Rezoning Transportation Analysis

Petition Number: 2024-011

Date	Description
02-21-24	First Review (TM)
03-20-24	Second Review (TM)
05-23-24	Third Review (TM)

The site is located on a City-maintained, 2+ Avenue Johnston Oehler Road. Based on the 826 daily trips, the petitioner will be required to satisfy Tier 1 Multimodal assessment (3 points). Site plan and/or conditional note revisions are needed to commit to CTR improvements. Further details are listed below.

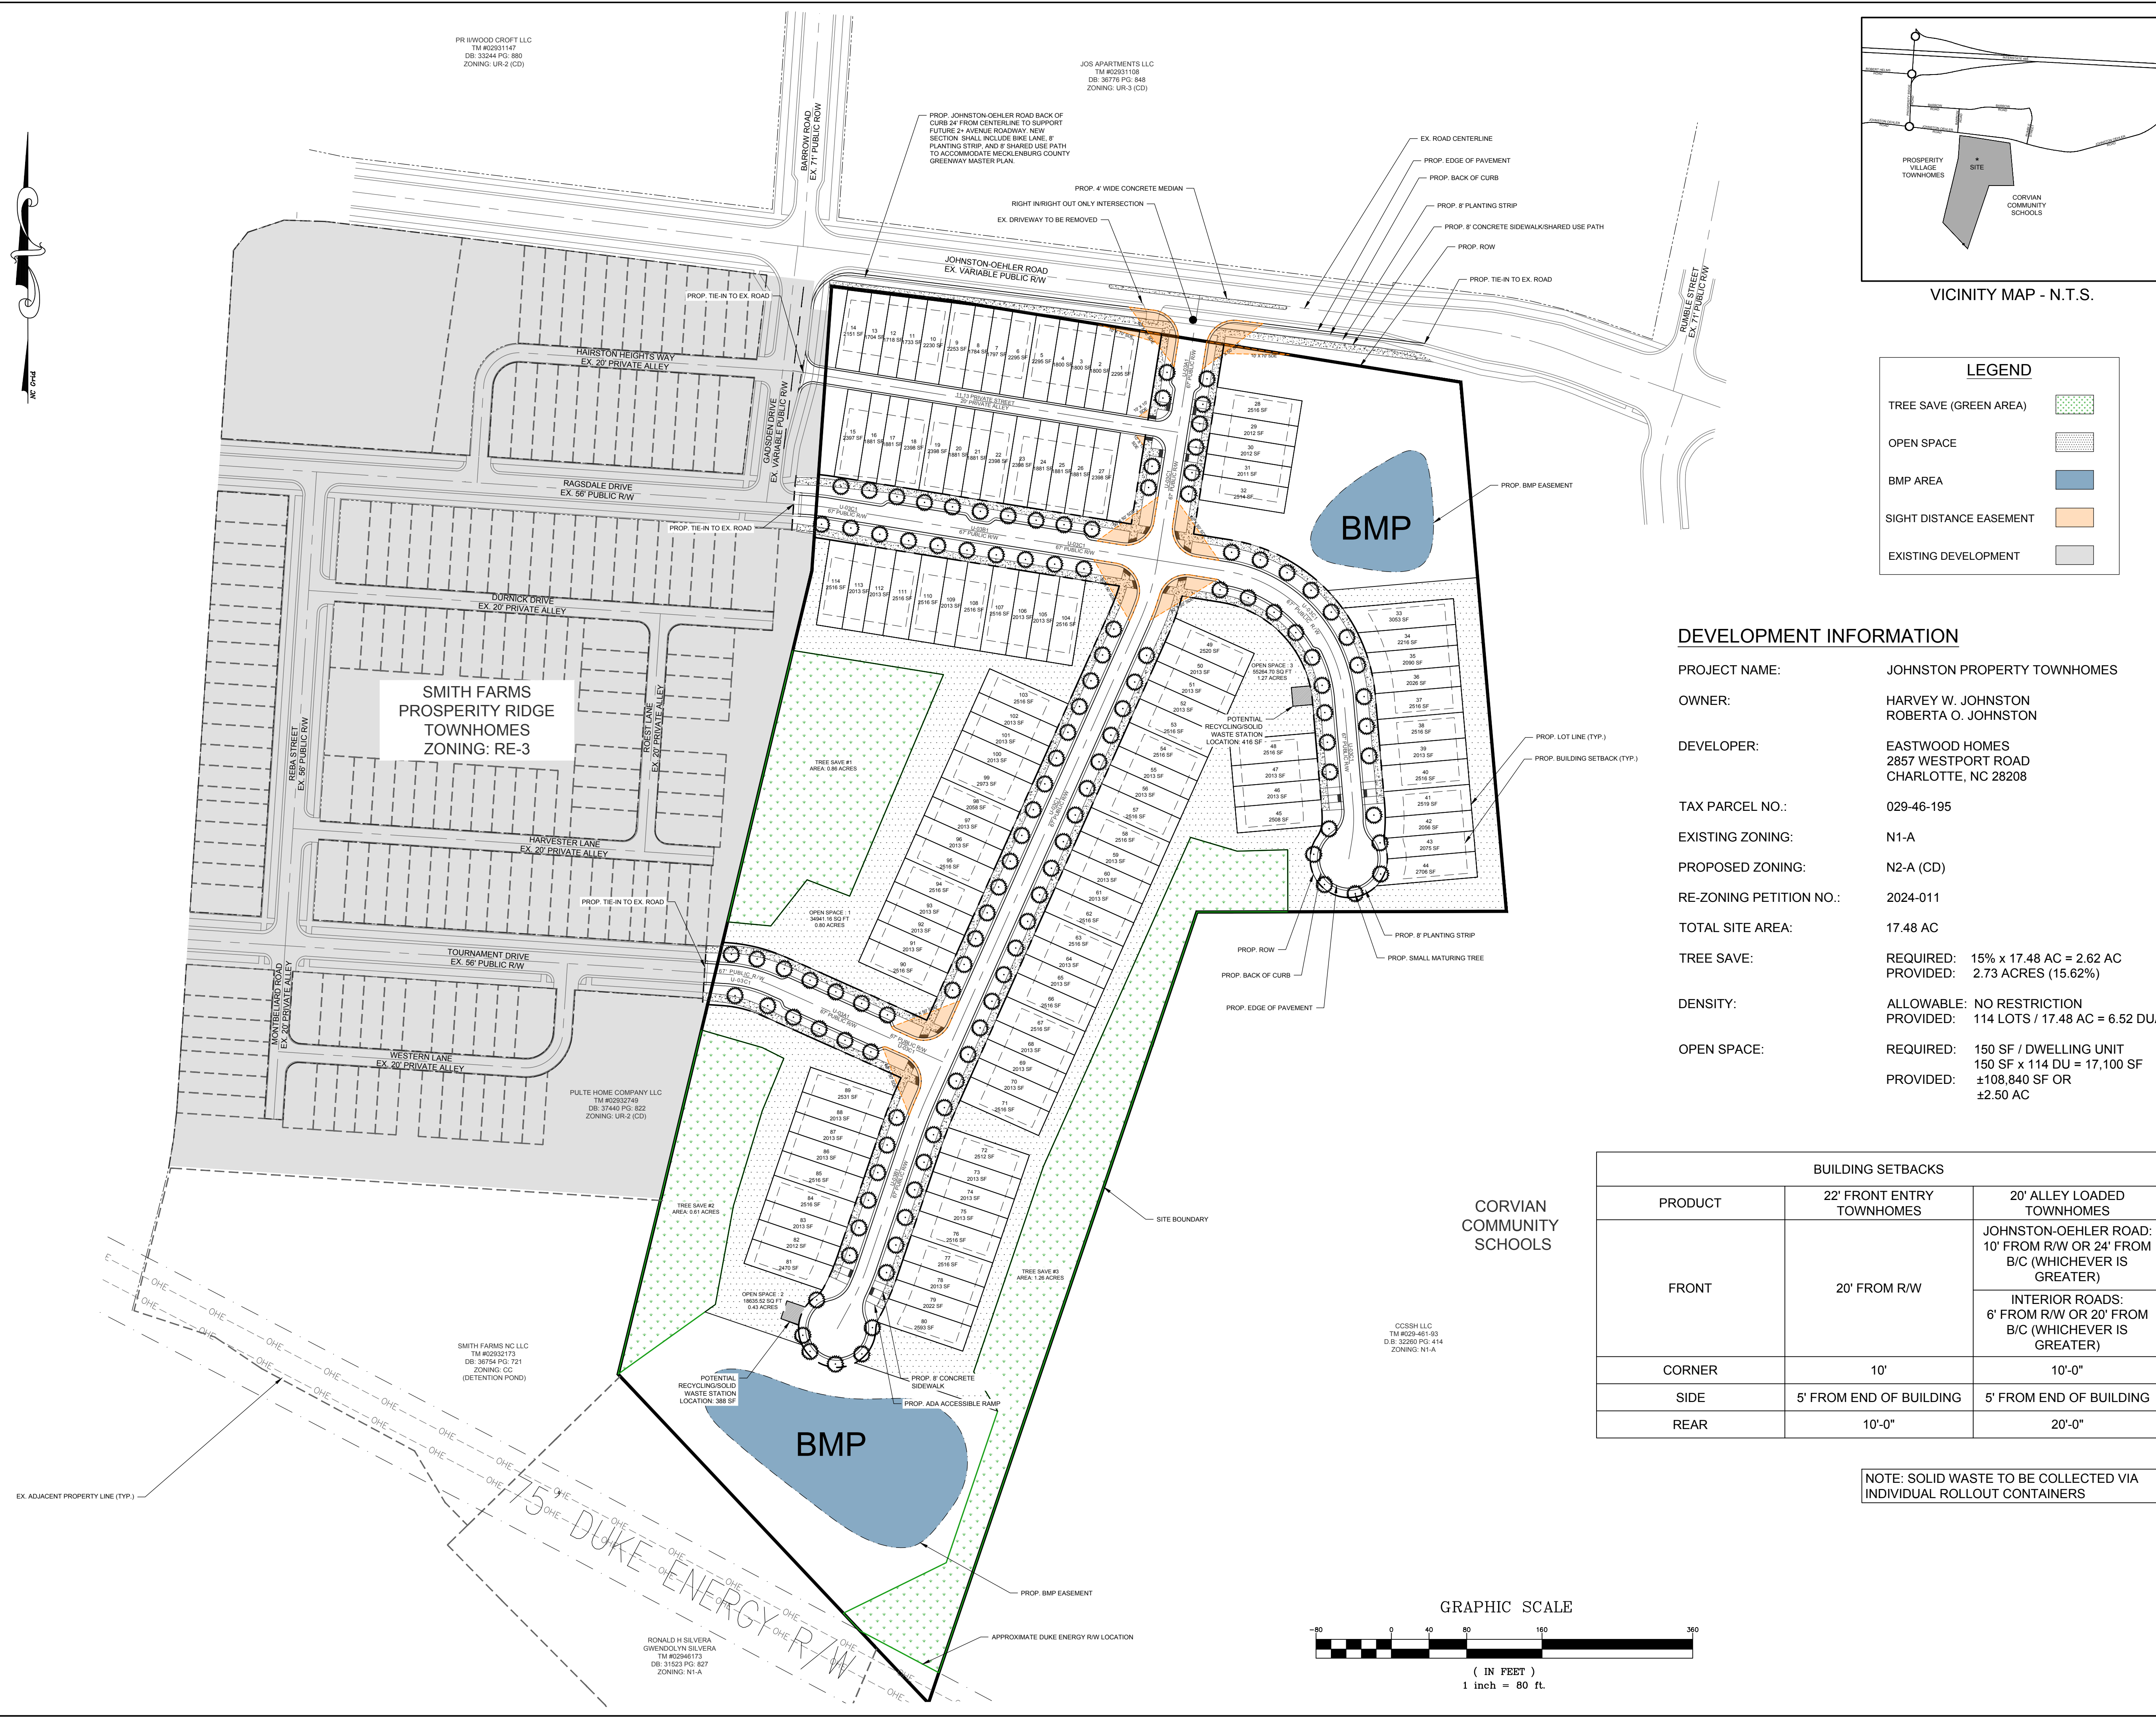
Label and dimension the curb and gutter from the centerline for each road on the site plan.

Clarifying Comment 05-23-24: Add CTR table with offsite commitments to the site plan.

Clarifying Comment 03-20-24: An 8 foot planting strip and 8 foot sidewalk are required in N-2 per UDO chapter 33. Revise site plan to commit to installing an 8 foot sidewalk throughout the site on all public roadways.

2+ AVENUE ROADWAY PER CHARLOTTE STREETS MAP

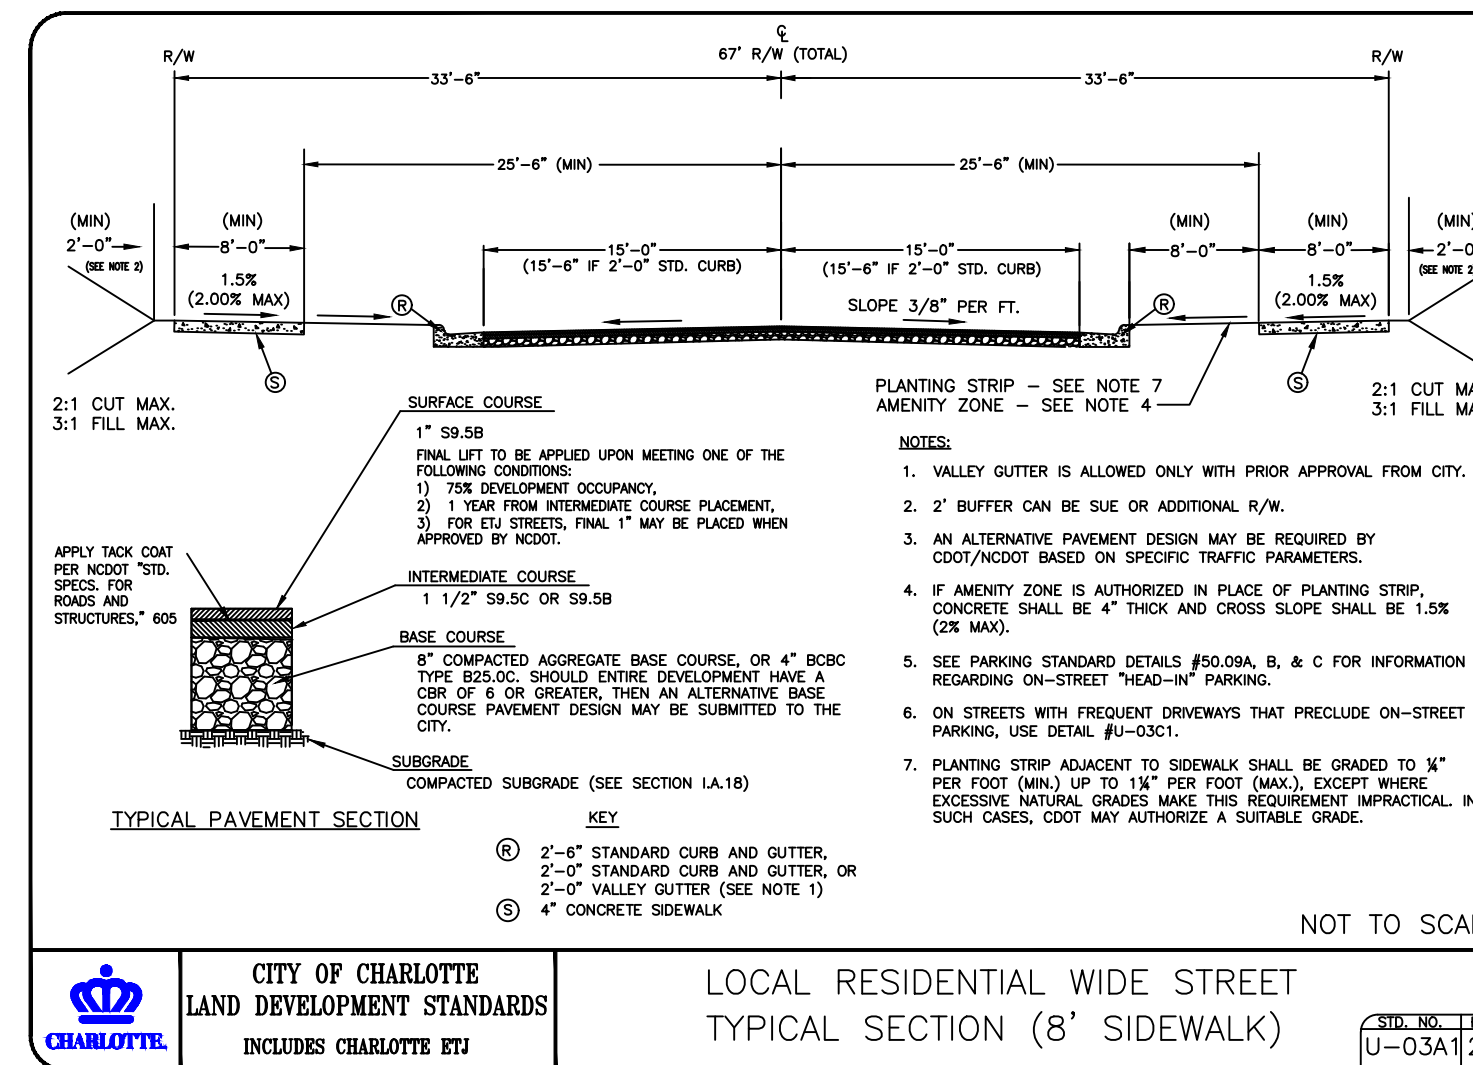
- a. ~~Johnston Oehler Road: Location of future curb and gutter is to be relocated to 24 feet from the roadway centerline. Per CLDSM 11.09.~~
